WEST SUSSEX COUNTY COUNCIL CONSULTATION

TO:	Arun District Council FAO: Mrs A Gardner
FROM:	WSCC - Highways Authority
DATE:	31 March 2022
LOCATION:	28 Arundel Road, Littlehampton, BN17 7DB
SUBJECT:	LU/69/22/PL Change of use from abandoned amenity space to temporary caravan site to house refugees. This site is in CIL Zone 4 (Zero Rated) as other development.
DATE OF SITE VISIT:	n/a
RECOMMENDATION:	Advice
S106 CONTRIBUTION TOTAL:	n/a

Block Plan

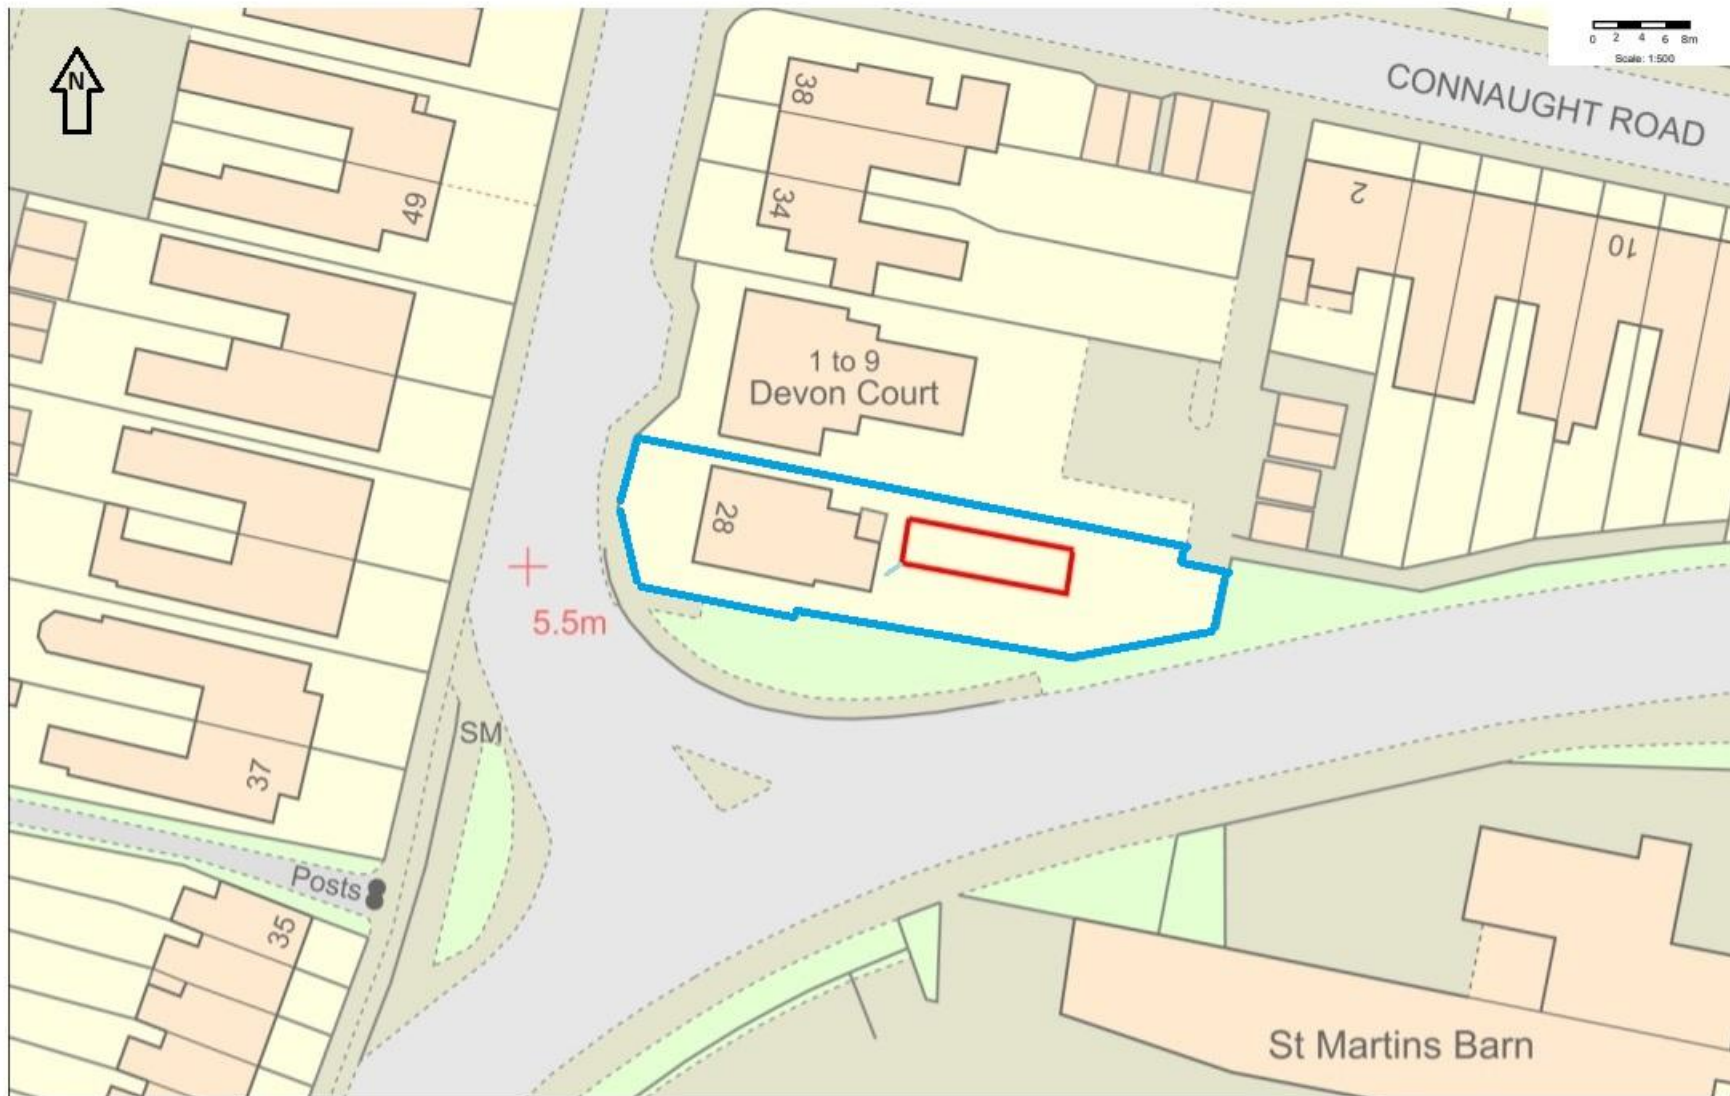
After inspection of aerial photography, it seems there is a vehicle parking area to the rear of 28 Arundel Road accessed via Connaught Road. Presumably this serves the 4 flats located at 28 Arundel Road? Nevertheless, this area seems to be outside the red edge plan and it is not being considered that any use of this parking area is to change as a result of this application.
